From:
Sent: 05 May 2023 15:50
To:
Subject: RE: 2022/92799 - 17, Town Gate, Upperthong, Holmfirth, HD9 3UX - Erection of extensions, conversion of existing attached barn to living accommodation, erection of garage and associated works (within a Conservation Area)
Attachments: 4416-06-04a Proposed Layout.pdf; 4416-06-05a Proposed Elevations.pdf; 4416-06-06a Proposed Sections.pdf

4416-06-04a Proposed Layout
4416-06-05a Proposed Elevations
4416-06-06a Proposed Sections

Number
4416-06-05a
Date
04/2023
Scale @ A1
As Marked

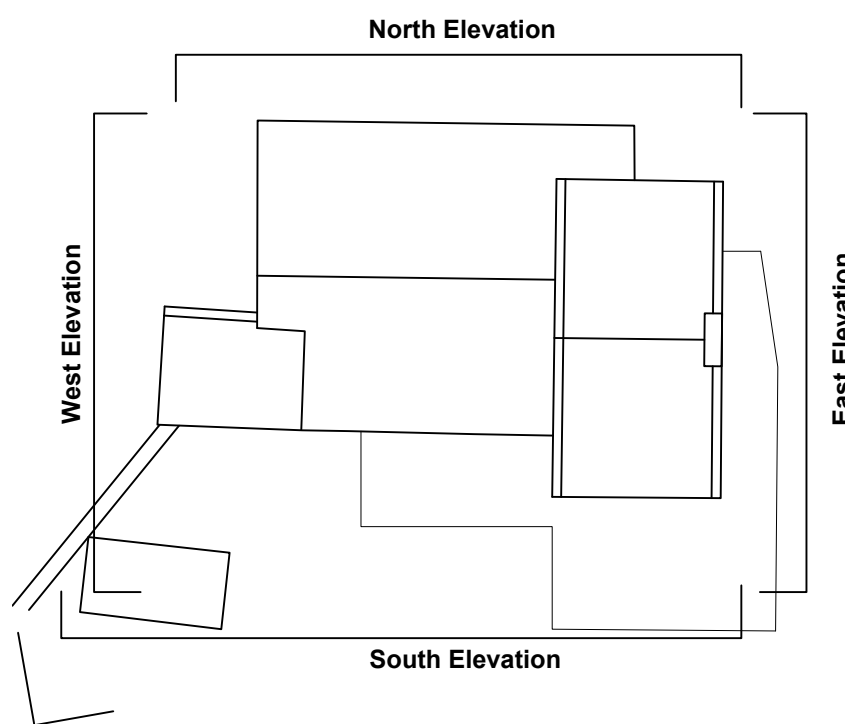
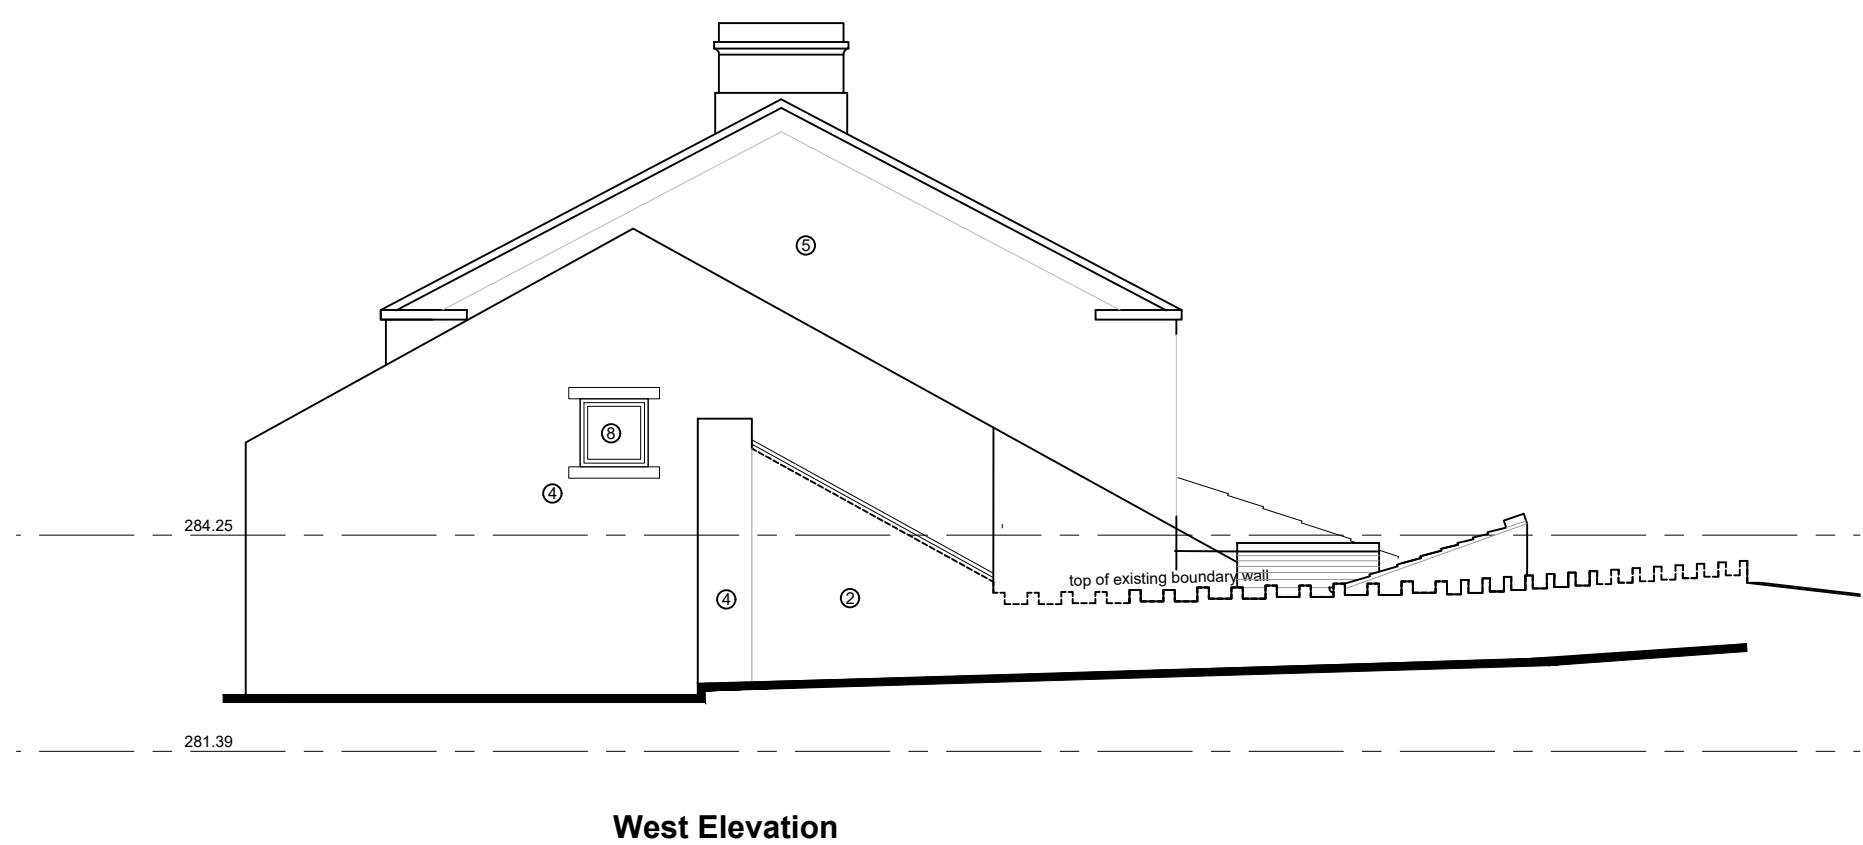
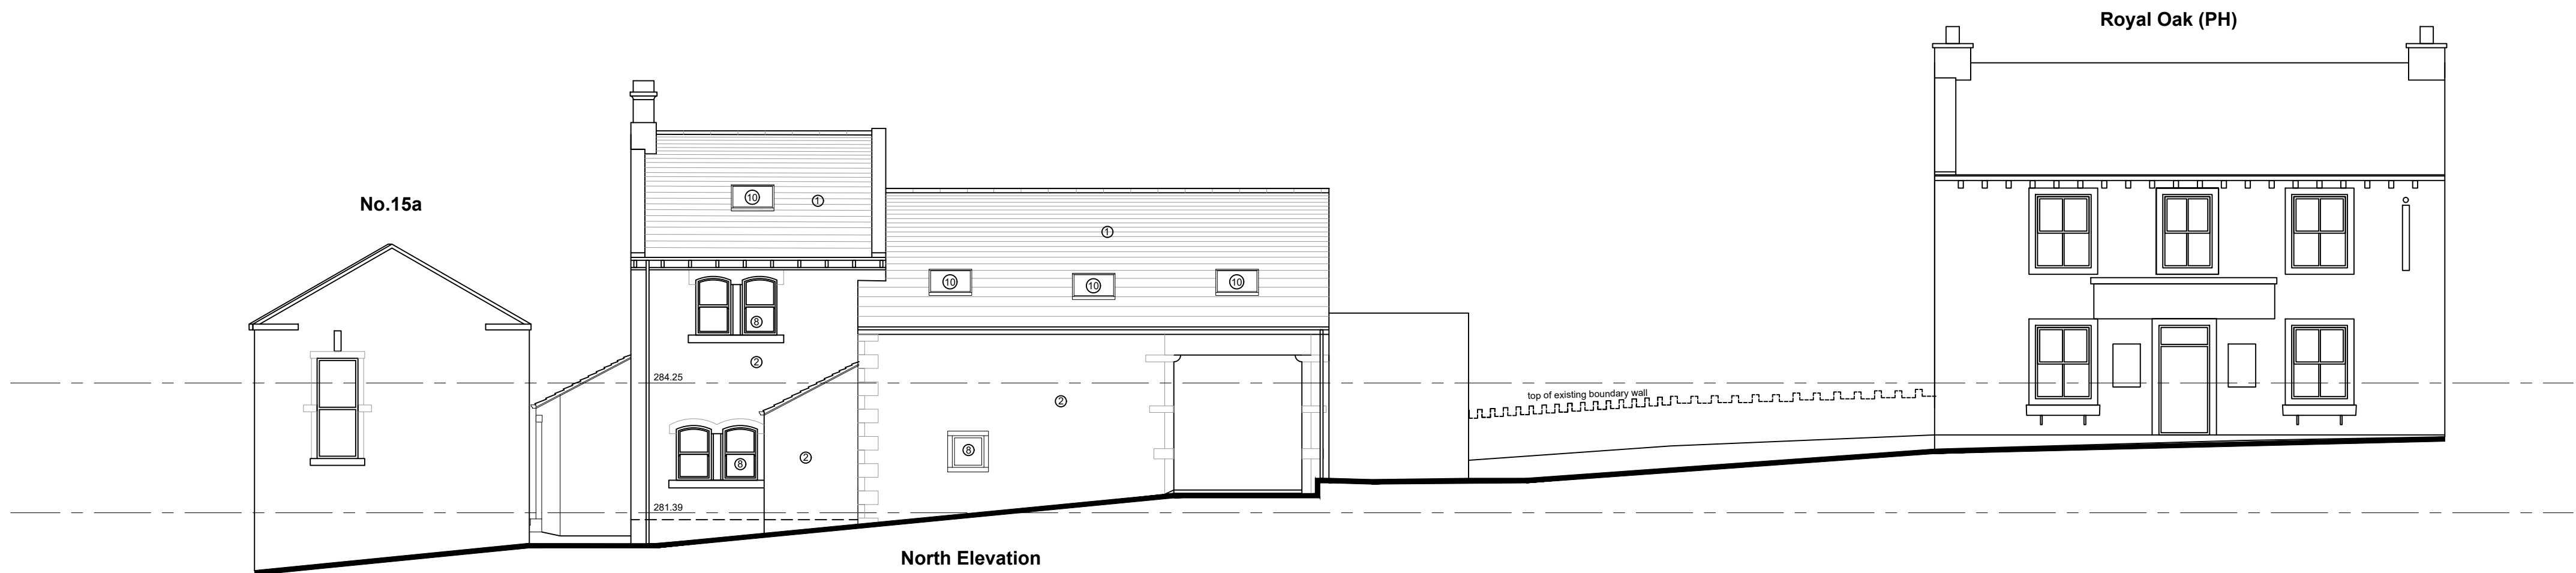
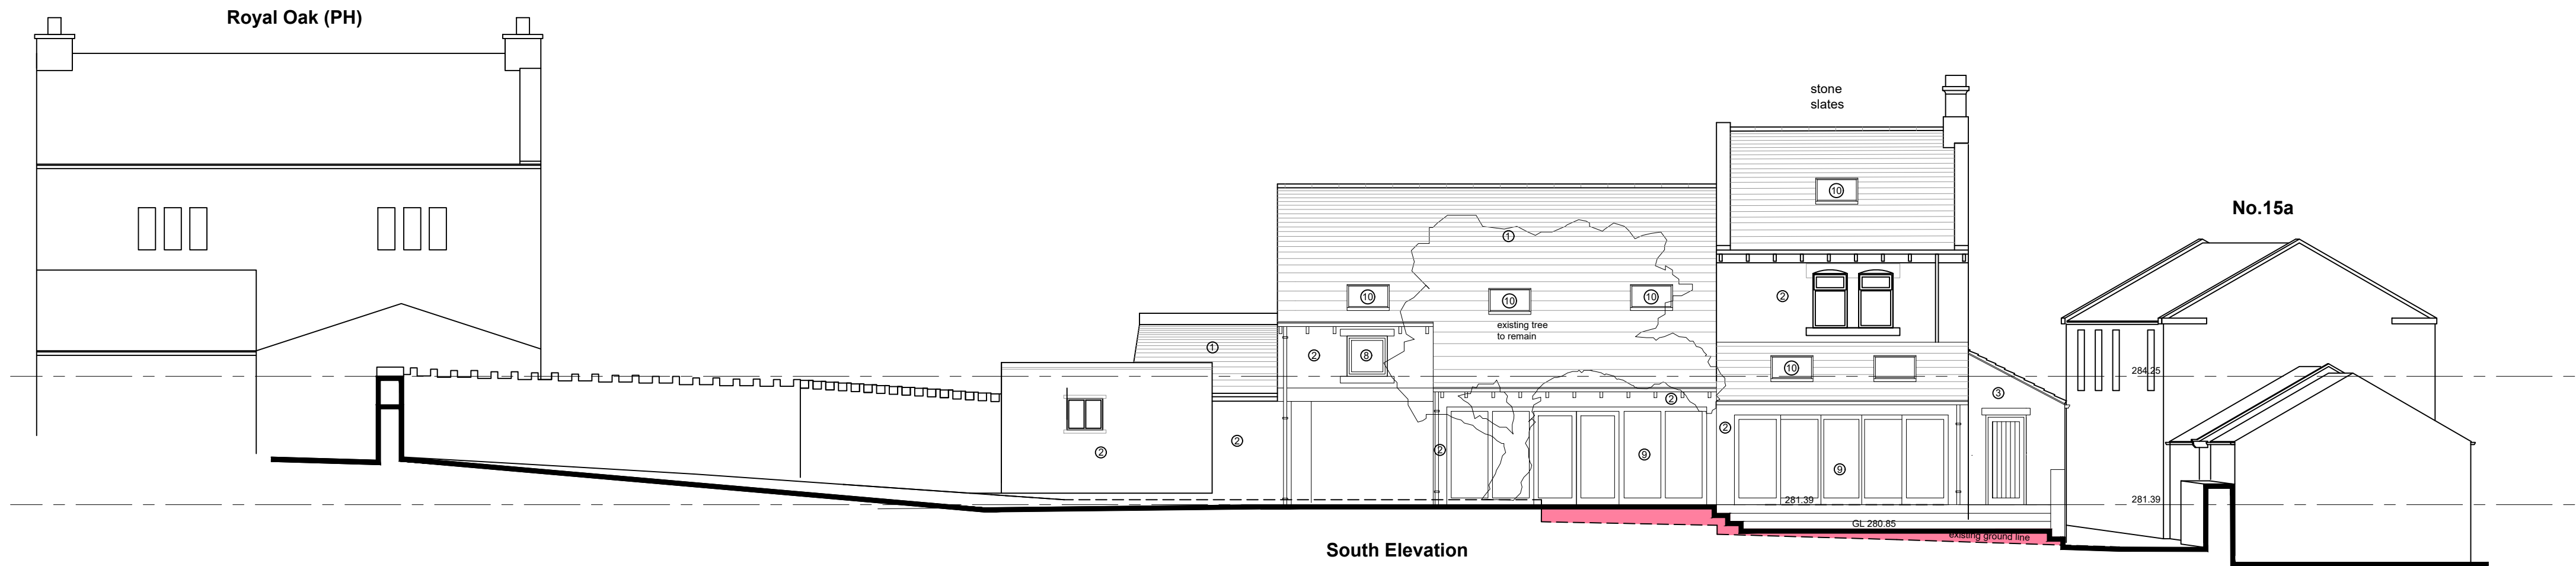
The two storey extension has been omitted from the application and replaced with a simple lean to extension. This proposed lean-to extension replaces the existing PVC conservatory which will need to be demolished to make way for the extension.

The proposed single storey side extension has been reduced in size to respect the smaller single storey extension in place of the existing conservatory.

On reflection the applicant wishes to replace the front PVC porch with a masonry and slate roof porch on the same footprint, as opposed to the timber glazed structure on the original submission. Also we have introduced a couple of additional windows under/within the barn drive through access to increase natural light in to the barn. This avoids additional windows to the barn frontage to ensure the barn still looks like a barn. These are both shown on the attached proposal.
